EL PASO COUNTY PLANNING AND COMMUNITY DEVELOPMENT DEPARTMENT

GRADING AND EROSION CONTROL PLAN CHECKLIST

GENERAL NOTES

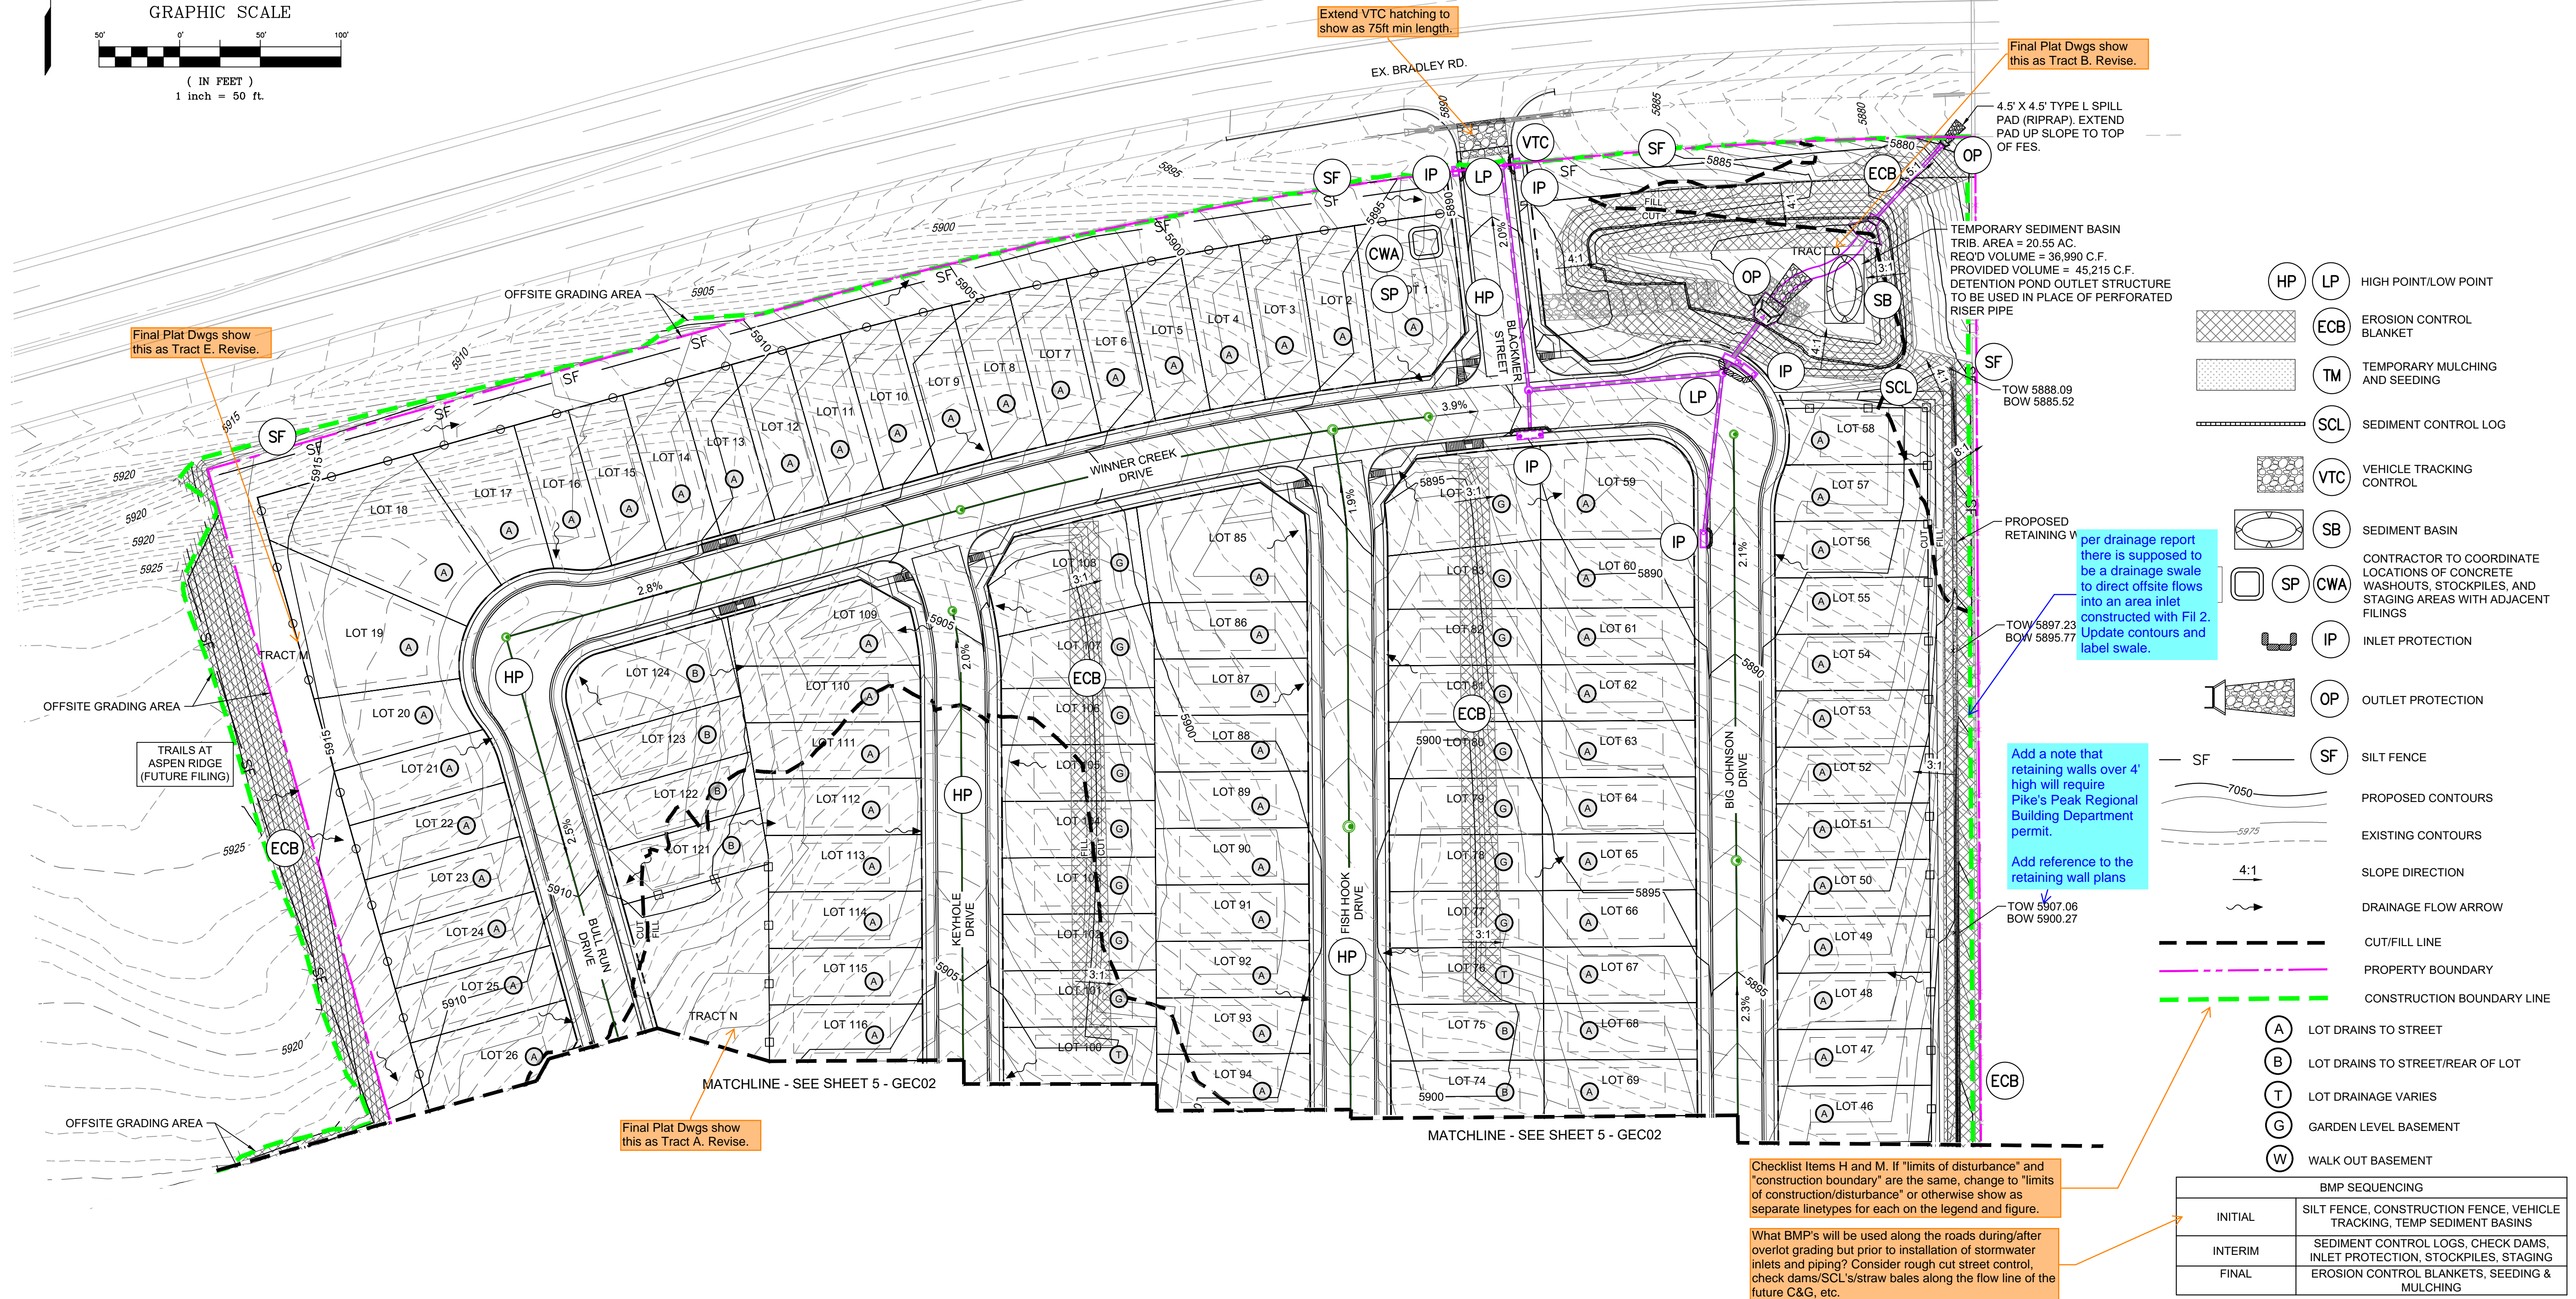
You have a note regarding vegetation on Sht 2.
 Revise this to "Y"
